## Jean Fraser - 133 York Street- Site Plan review update

**From:** Jean Fraser  
**To:** Tom Greer  
**Date:** 8/22/2013 5:35 PM  
**Subject:** 133 York Street- Site Plan review update  
**CC:** Barhydt, Barbara

## Passenger Car at 5 mph, Space 1

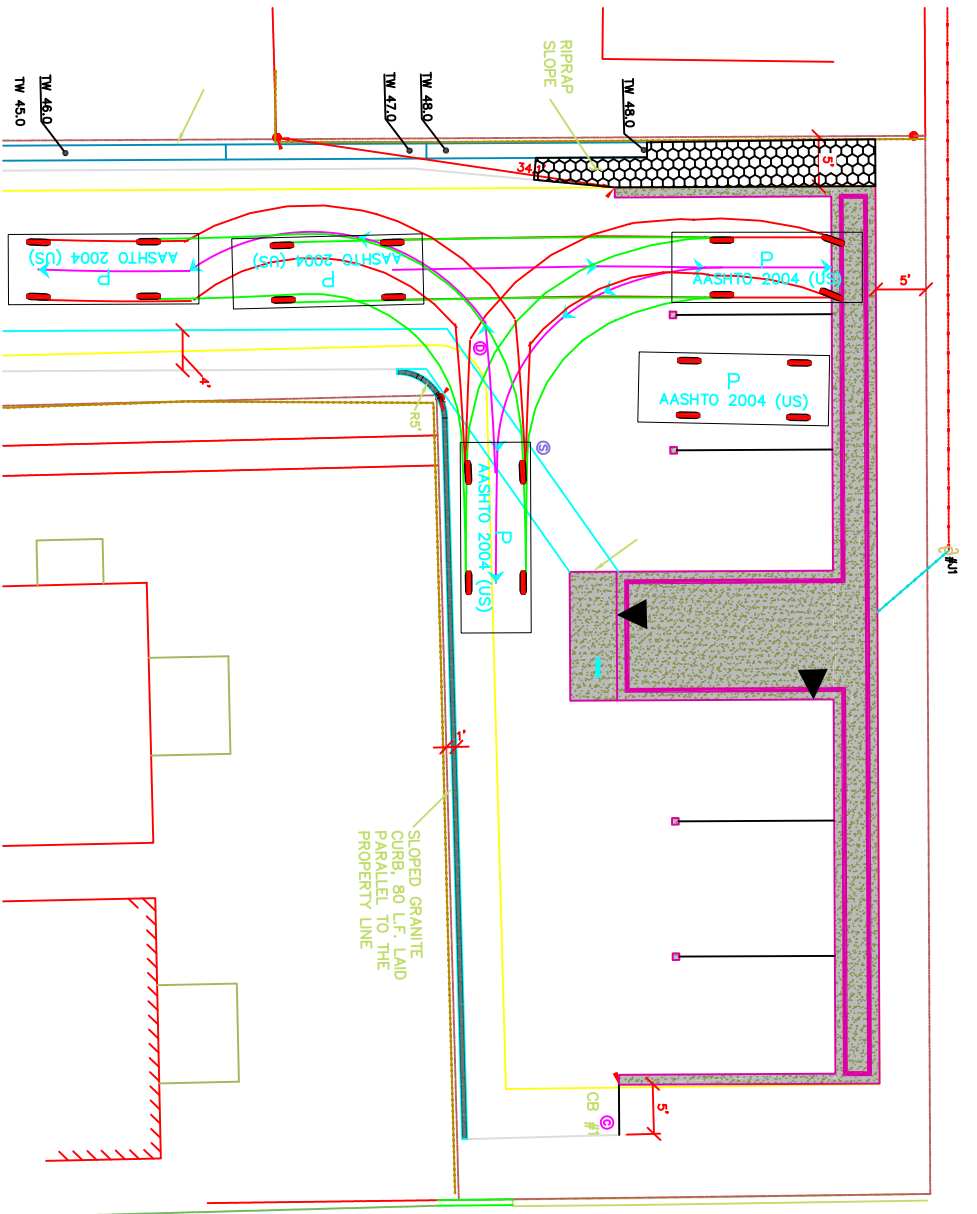
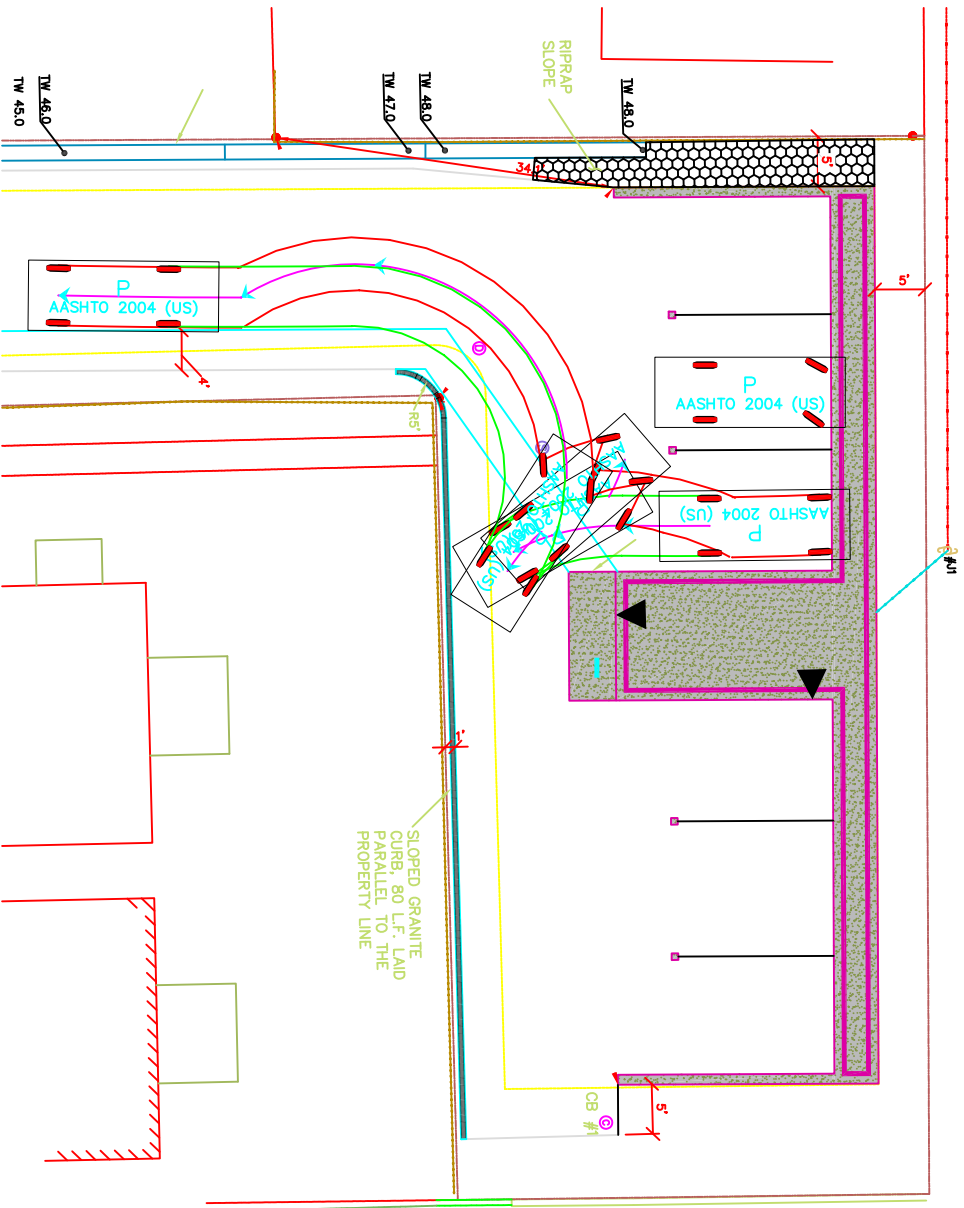
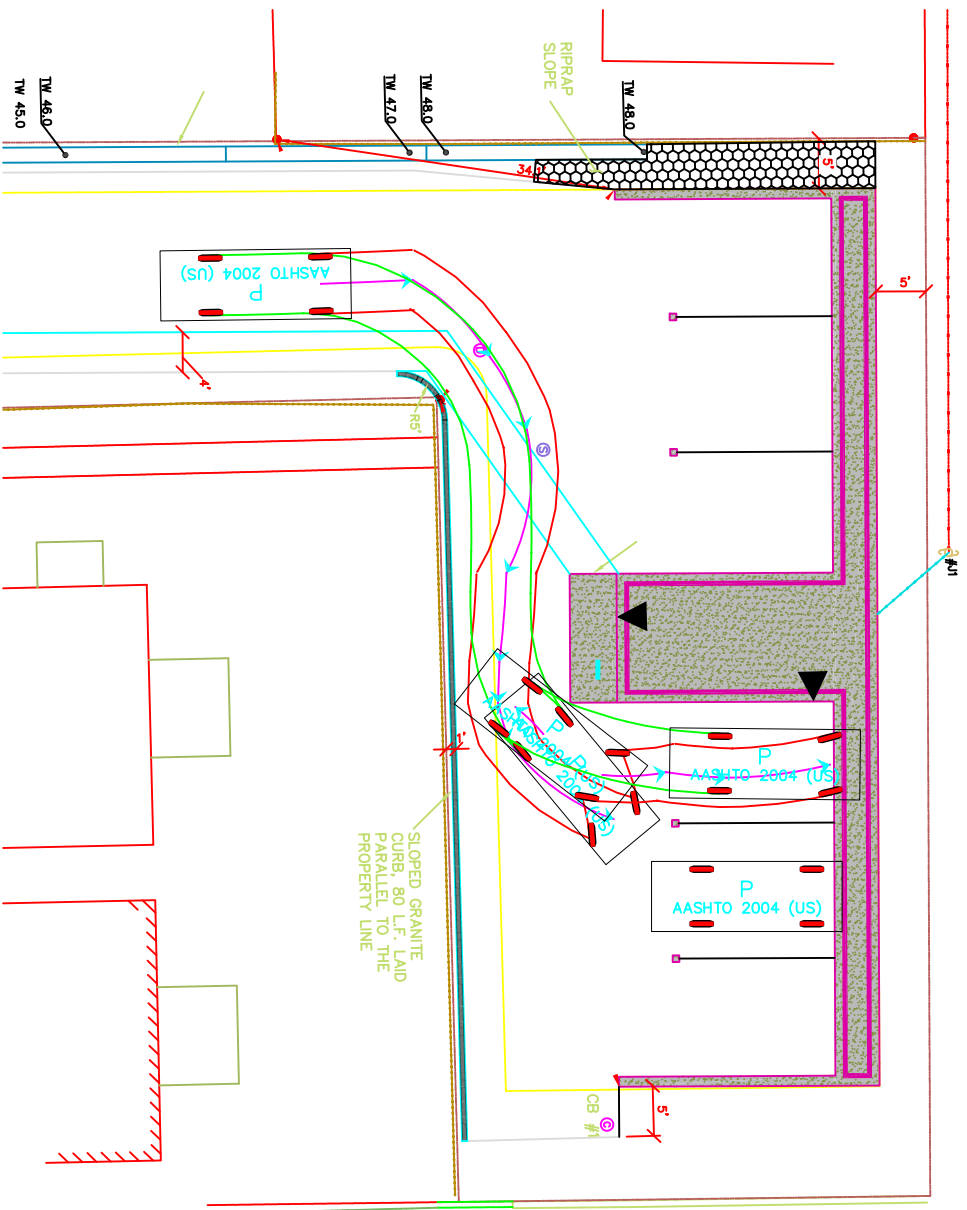
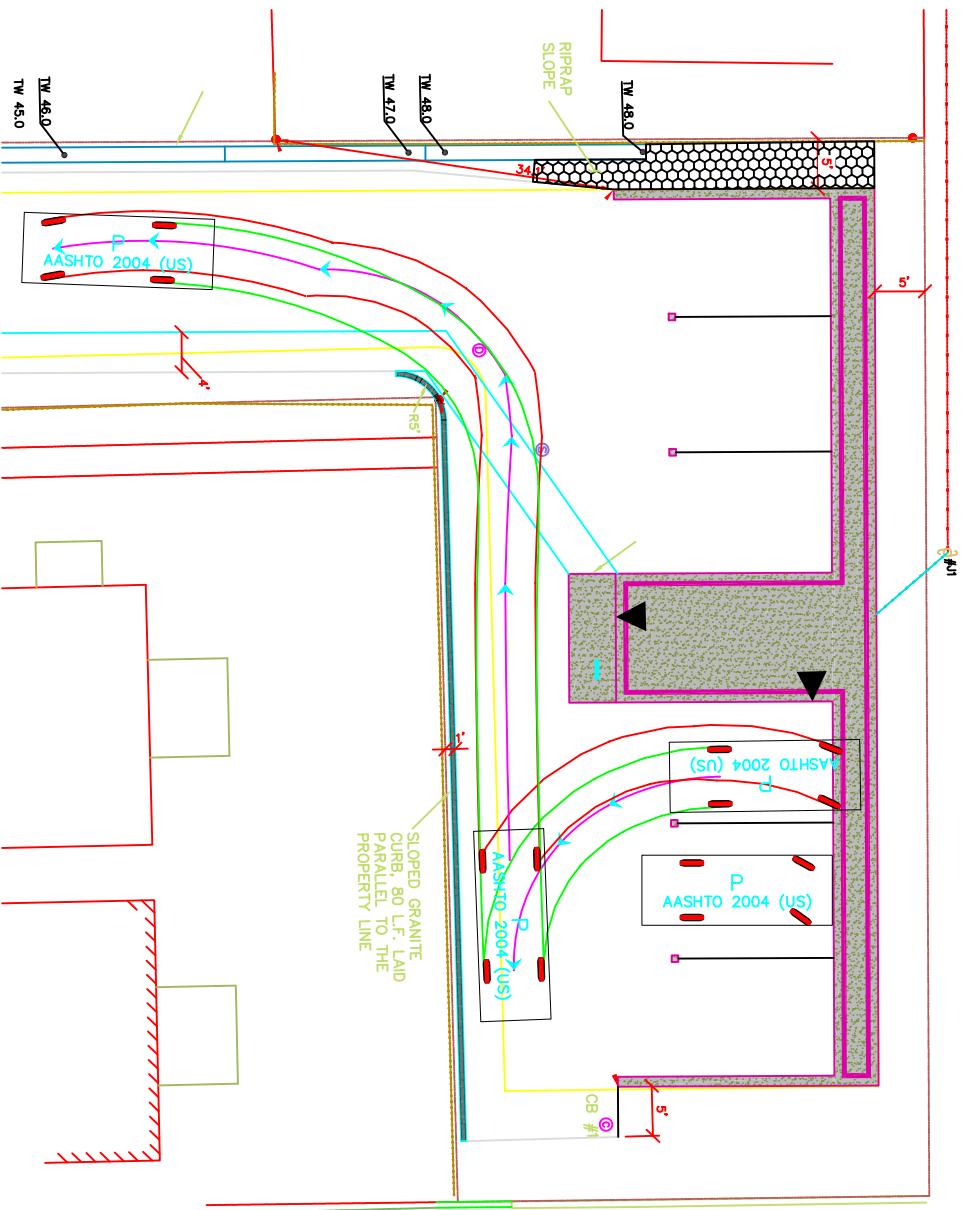
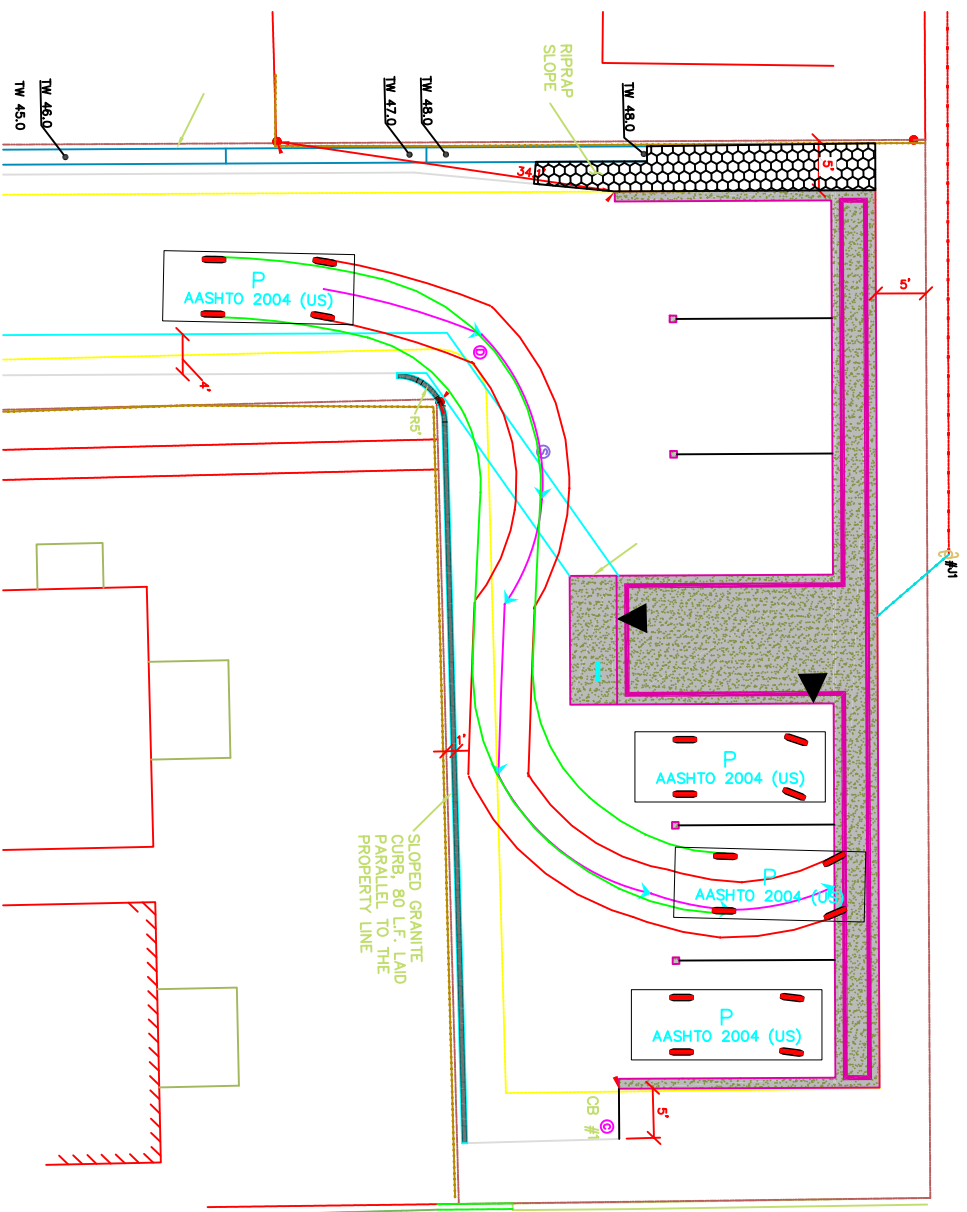
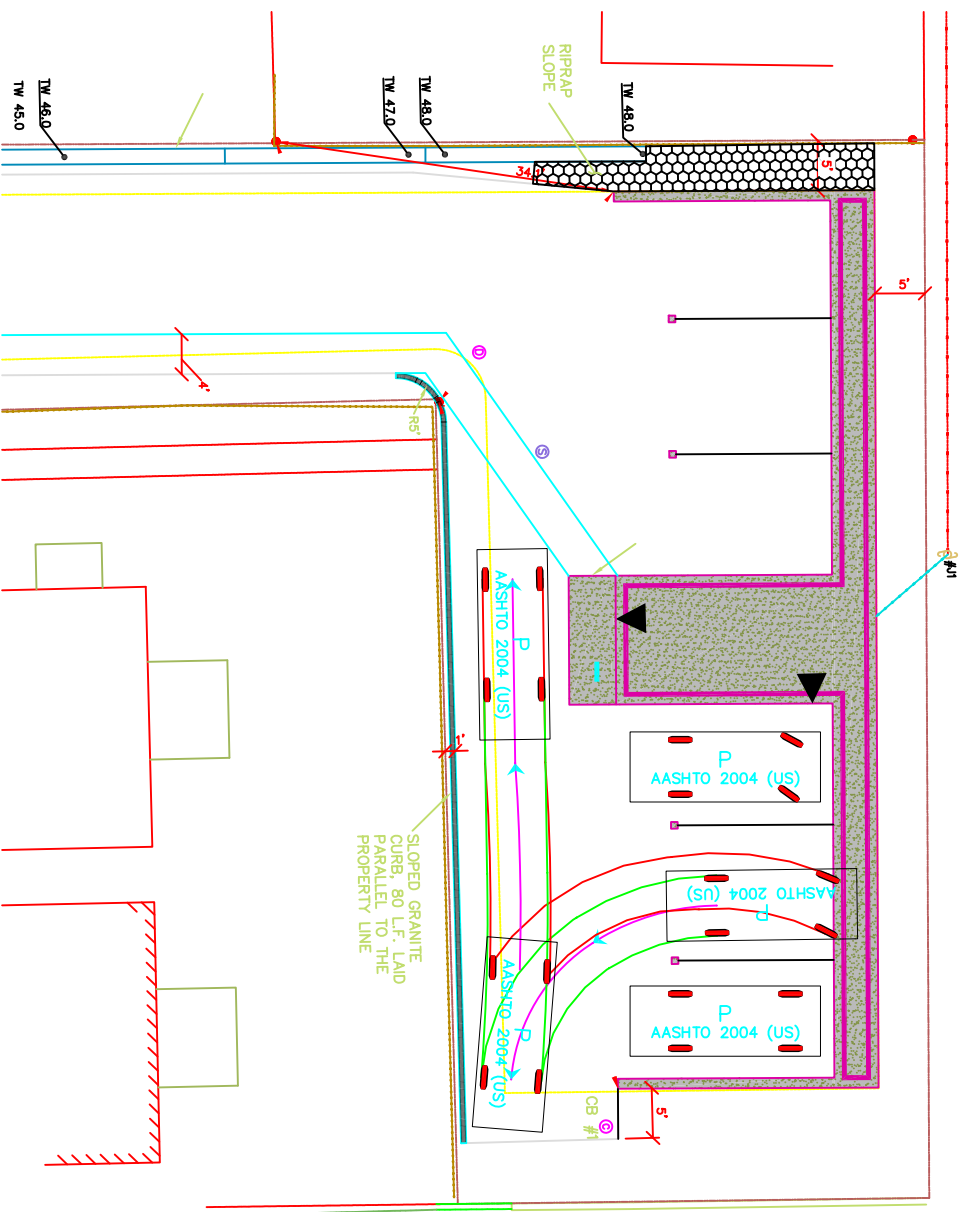
- There needs to be a dedicated pedestrian walkway from the York Street sidewalk to the front entrance;
- He would like to see turning templates to show that cars can get in and out of the parking spaces so they can exit going forward (ie the parking spaces at the north east end).
